# WINDERMERE PRELIMINARY PLAN

## E 1/2 OF SECTION 29, T13S, R65W OF THE 6TH P.M. EL PASO COUNTY, COLORADO

COUNTY FILE NO.: SP-19-003

### PRELIMINARY PLAN

OVERALL SITE  
PHASE PLAN

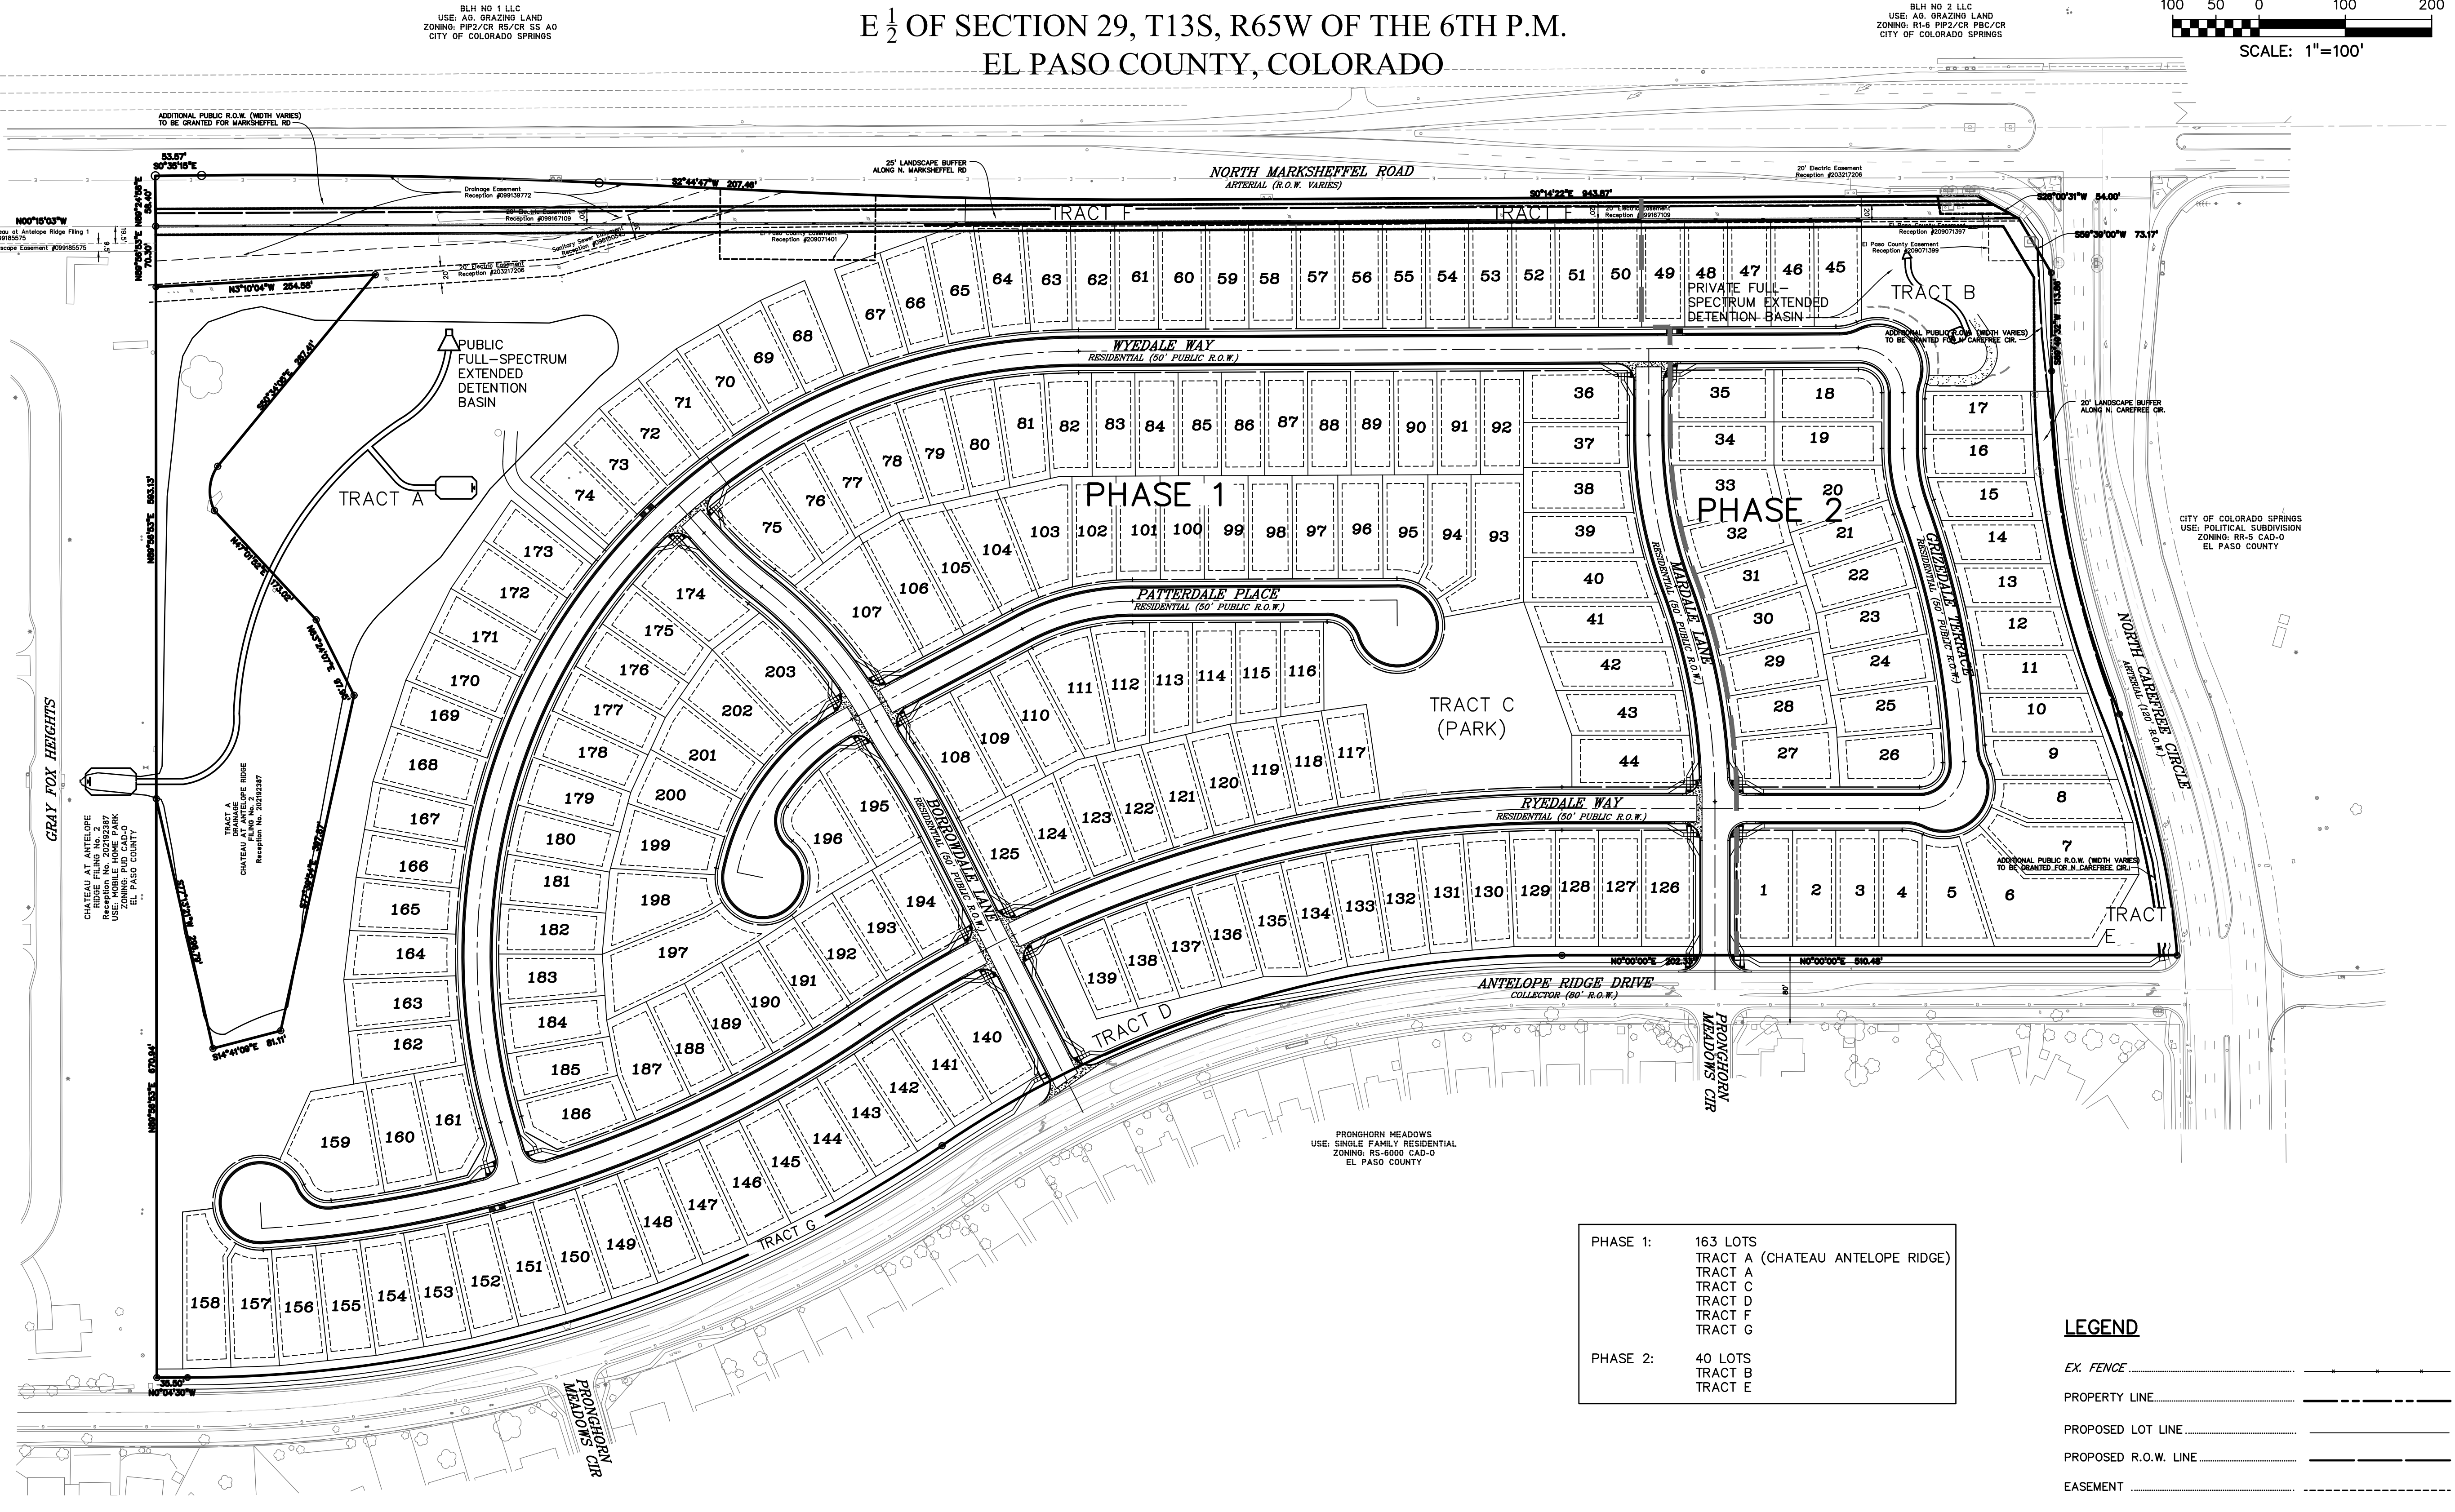
105' preservation  
43' dedication?

wall shouldn't be in the  
ROW preservation area

how many and what tracts with phase 1?  
phase 2 how many tracts, names?

### PRELIMINARY SITE PLAN

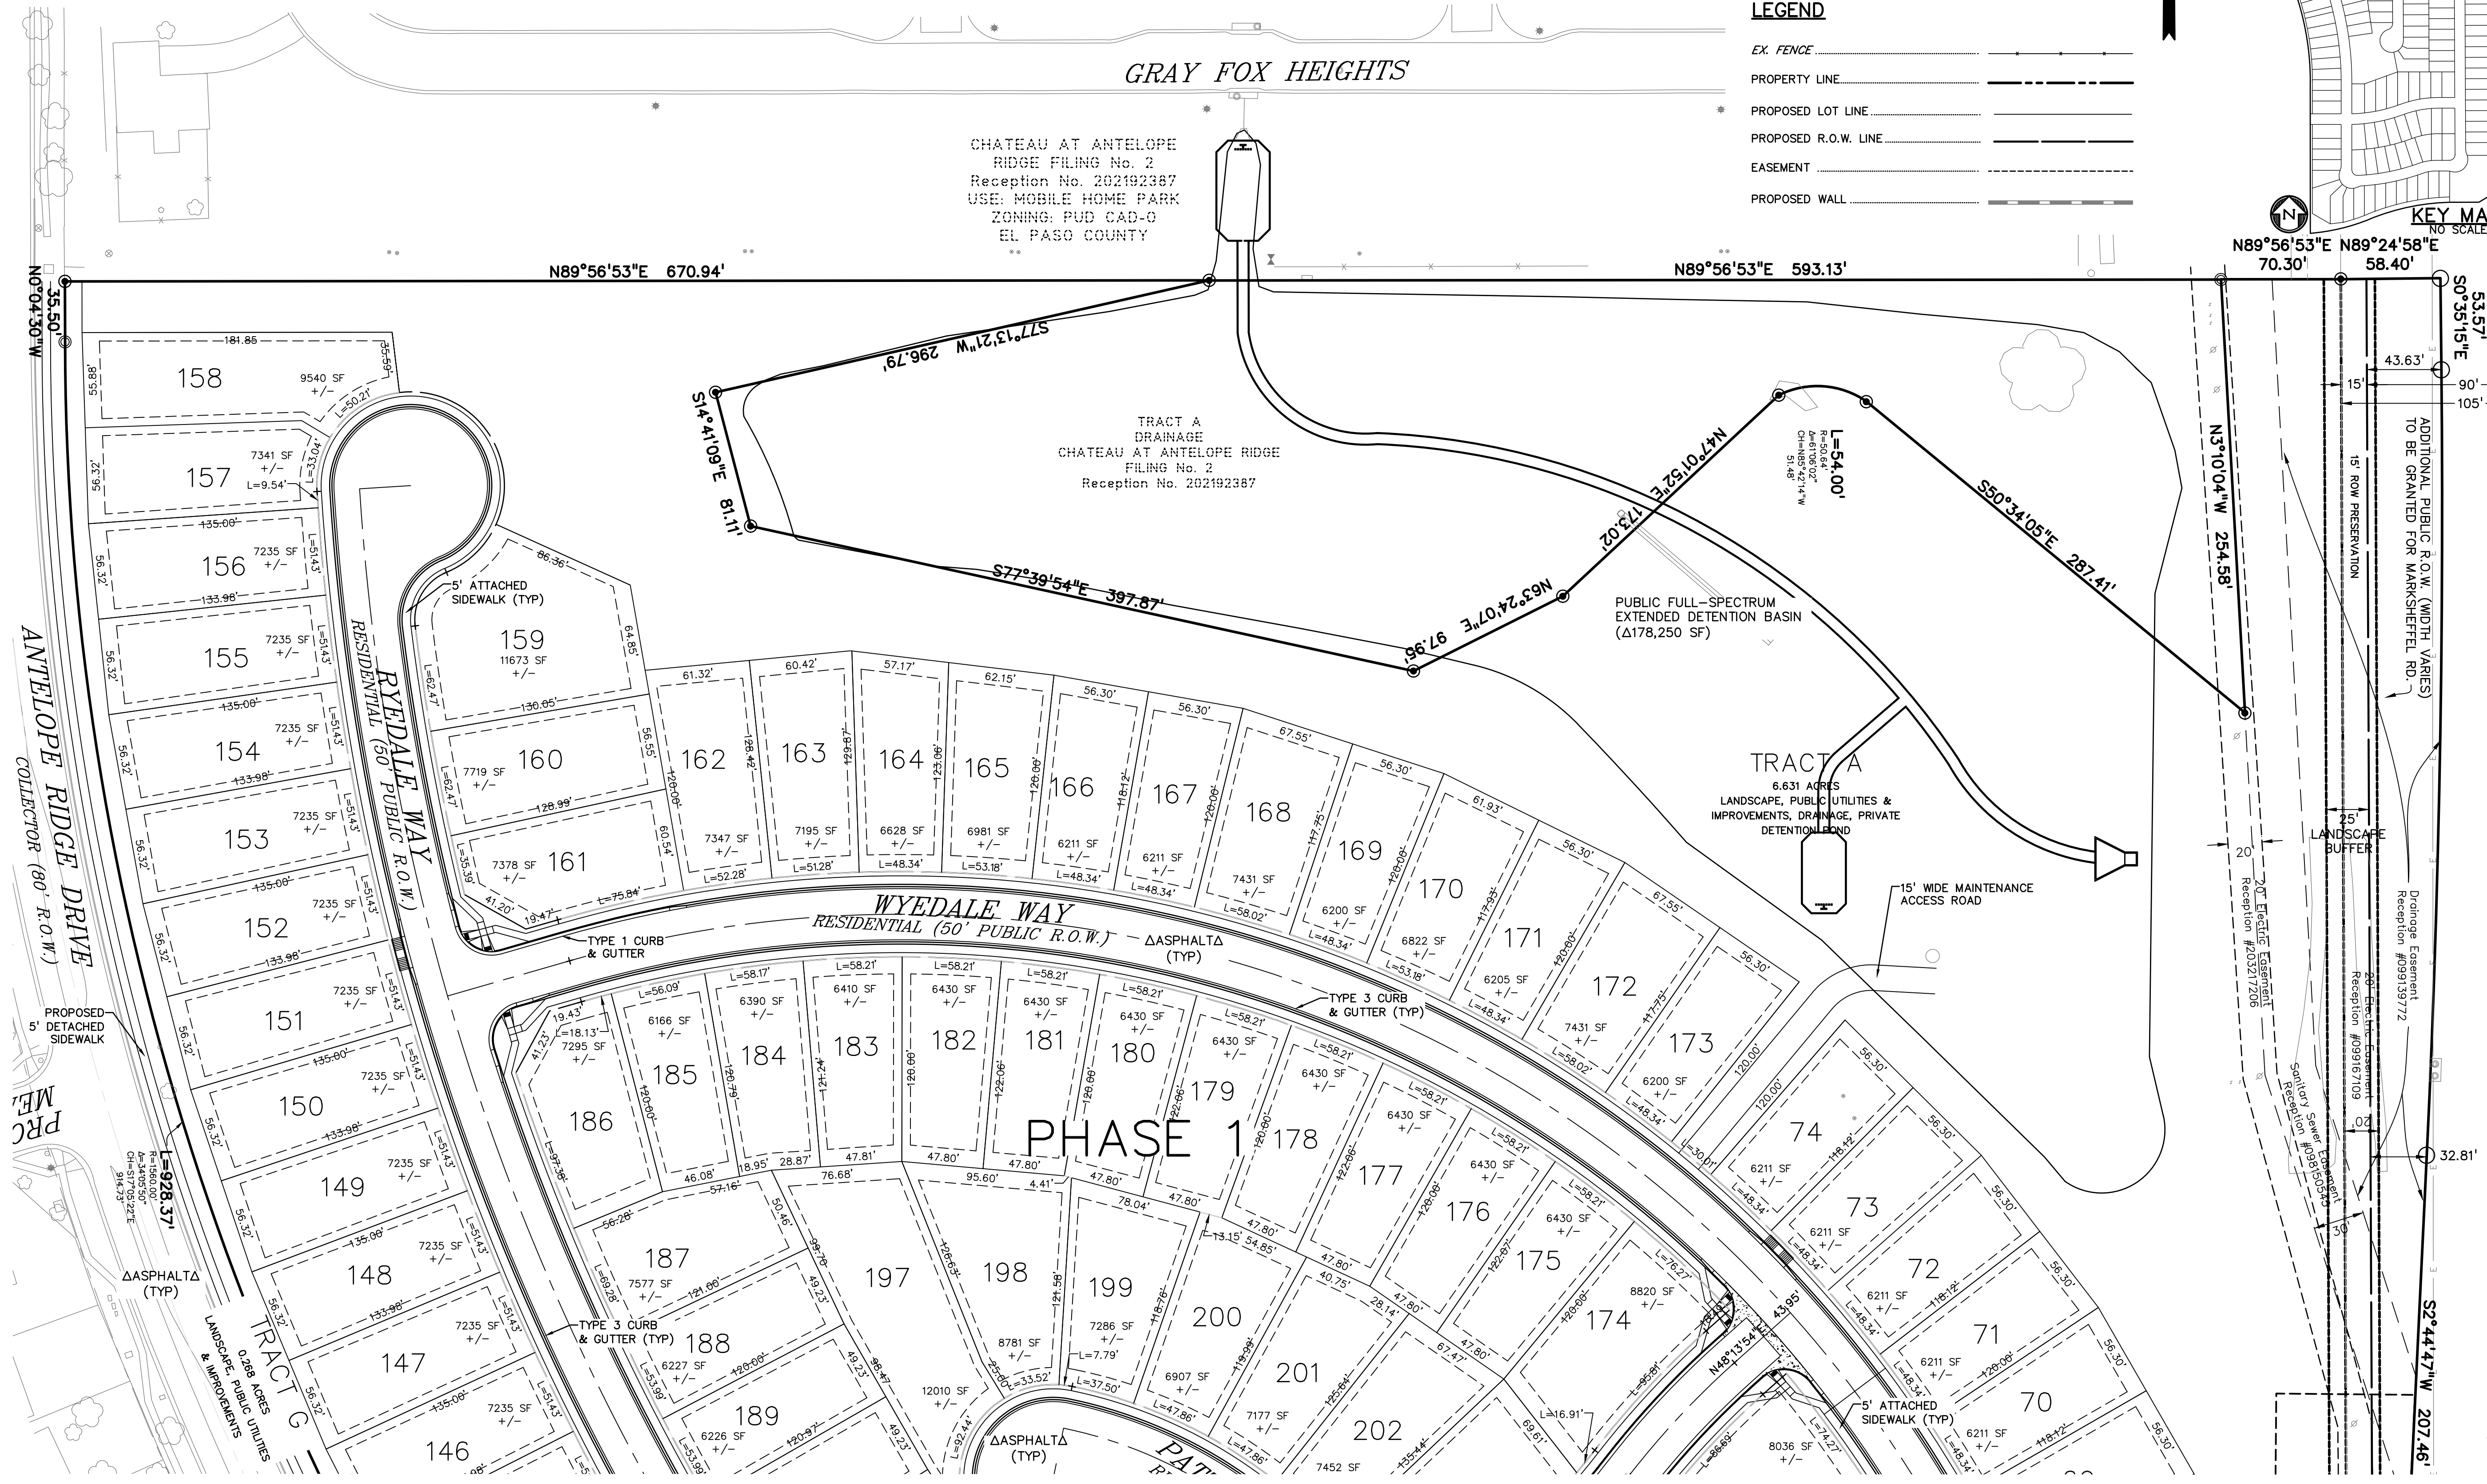
show labels

43.3' to get to 90' half ROW?

not a apt of this subdivision.

add sf or acreage  
and use for each tract  
label within prelim  
plan

**PRELIMINARY  
SITE PLAN**

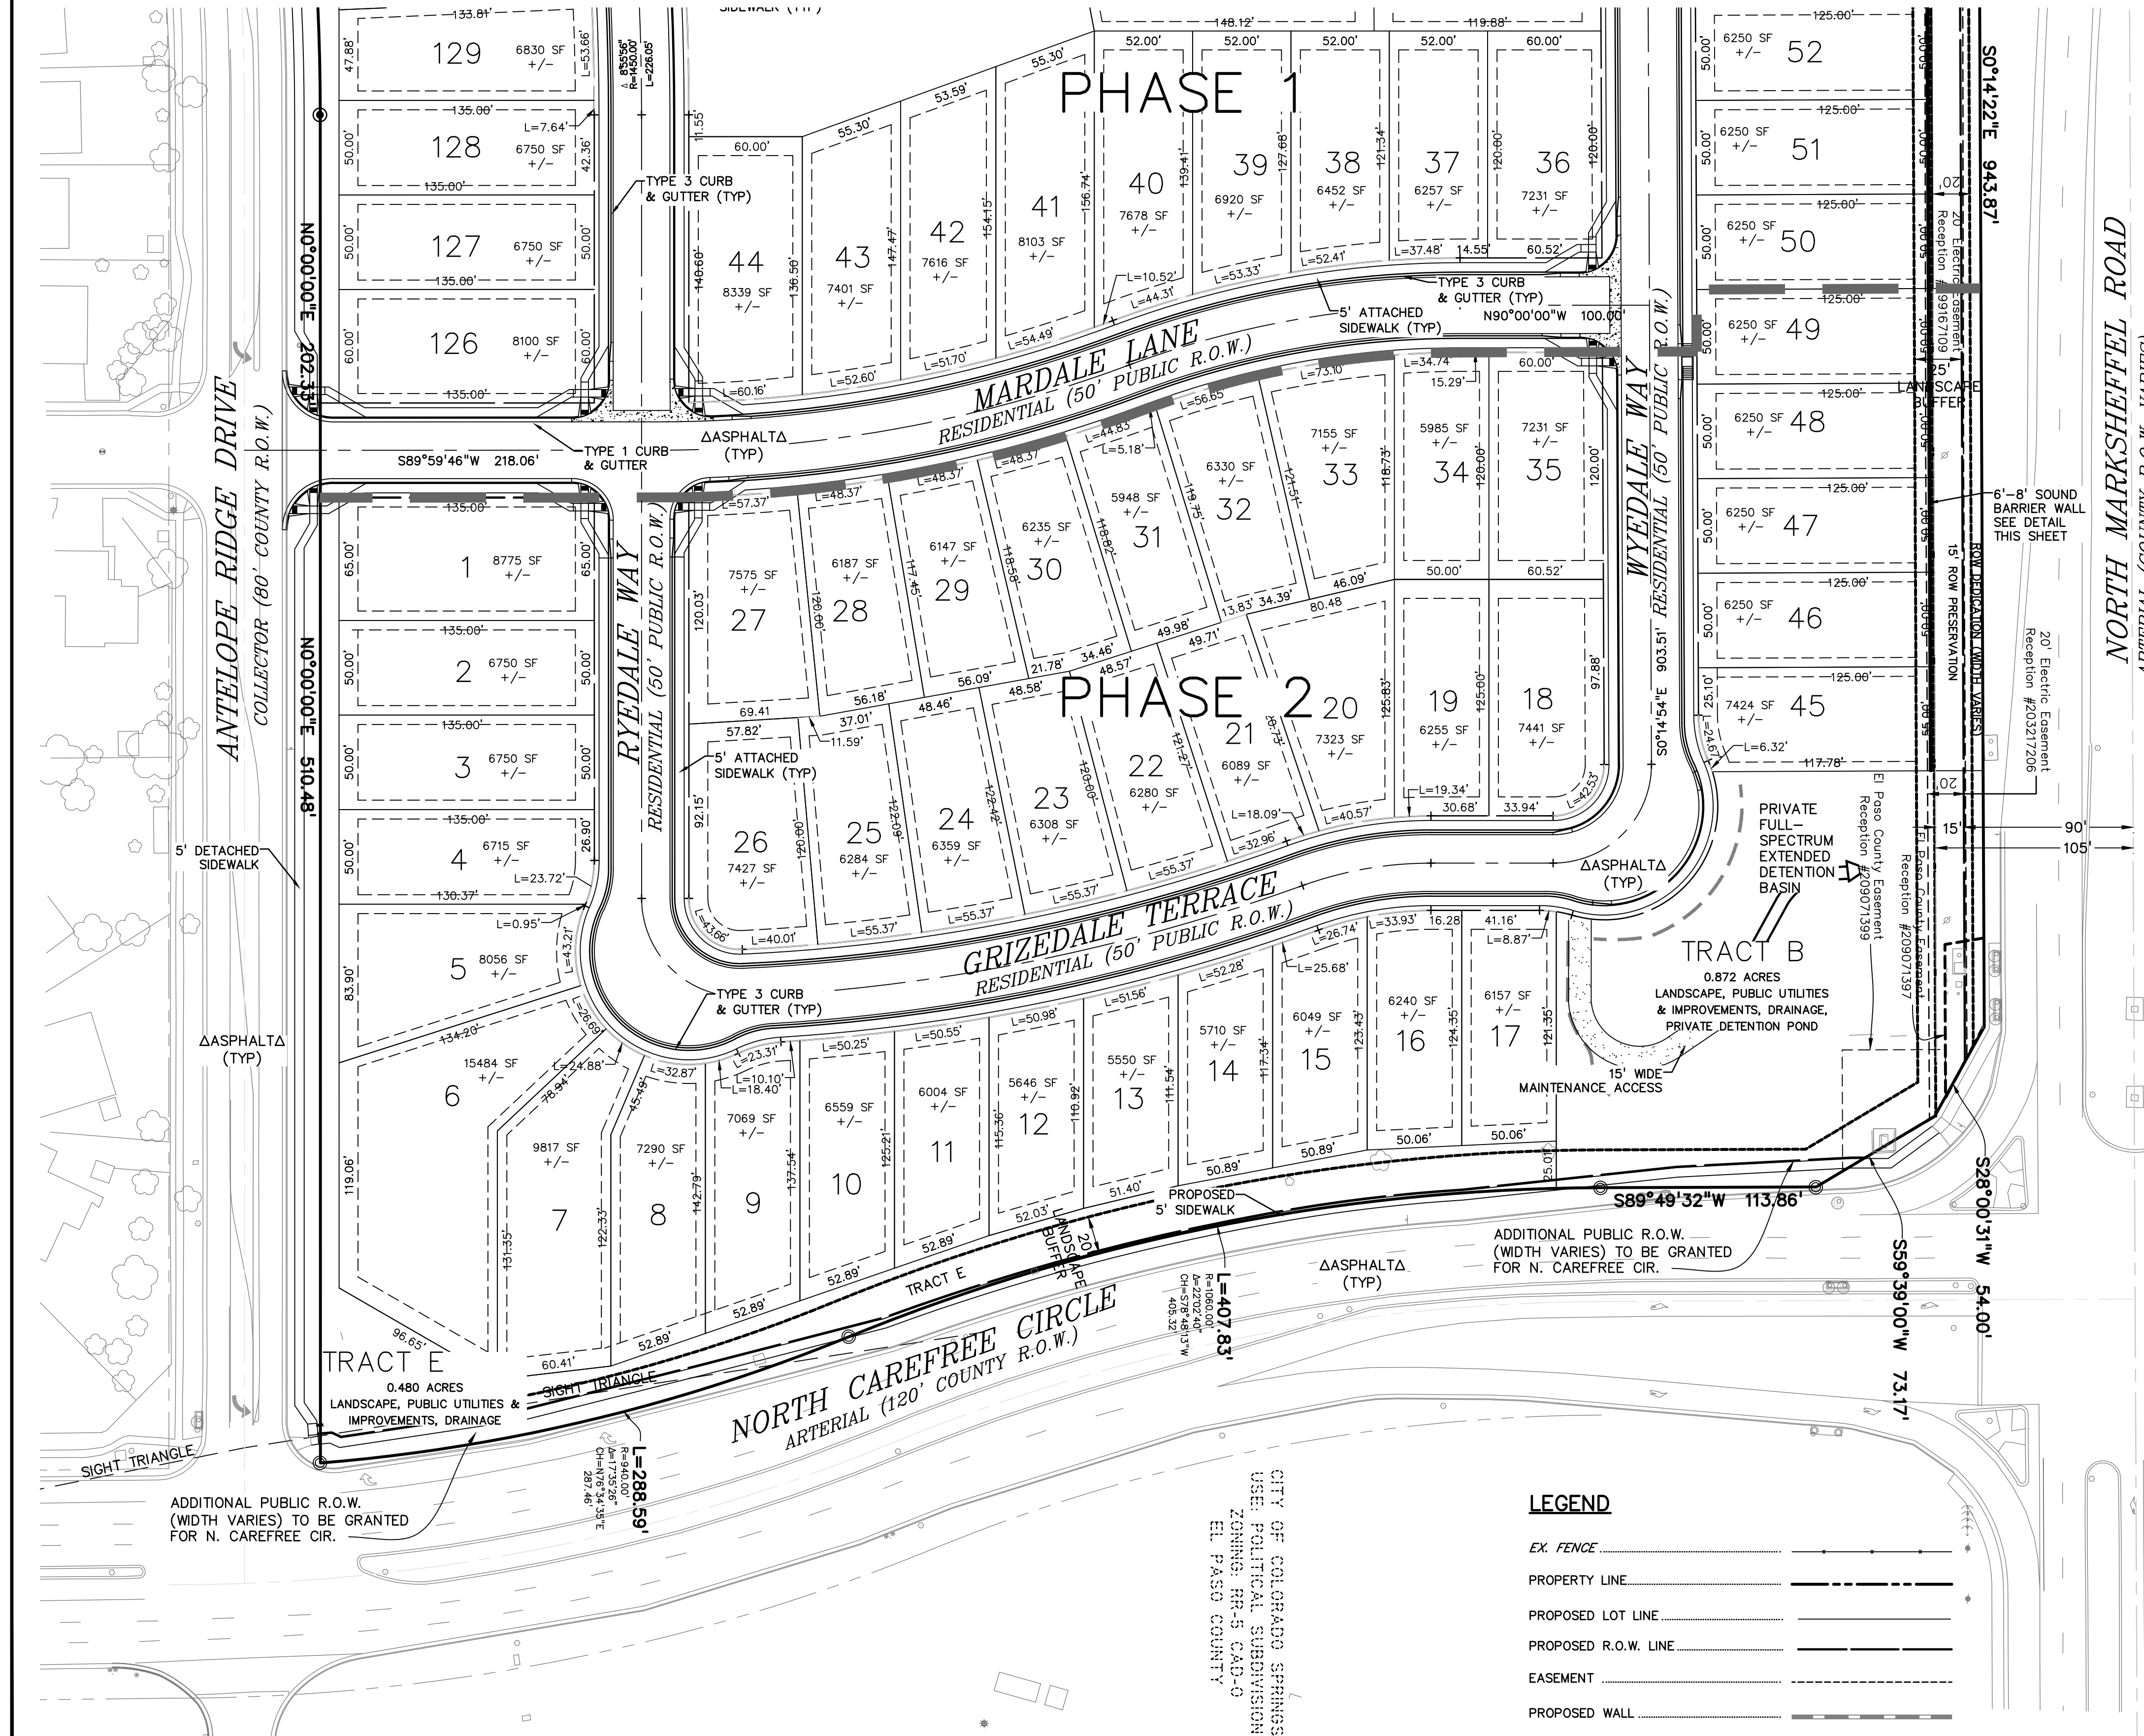
Are you not carrying this along the length of Marksheffel? Staff recommends you do. Marksheffel is a major arterial/truckroute classification. Many locations are over 66.5 db ...in 2019. This report gives no accounting of future, and you are nearly exceeding level a year ago. Staff will identify that as a concern in the SR.

Show and label ROW dedication and preservation.

label noise wall on sheets and provide details

8.4.2.A.1 requires a planting or screening easement adjacent to abutting collectors and arterials, expressways

noise wall ? FEB 2019 noise study is over 63 db; with the development occurring at current width not future width, in the area and increase in truck route, it reasonable to anticipated noise to exceed 67 db. Please provide the noise wall as staff will make that recommendation in staff report. 8.4.2.B.2
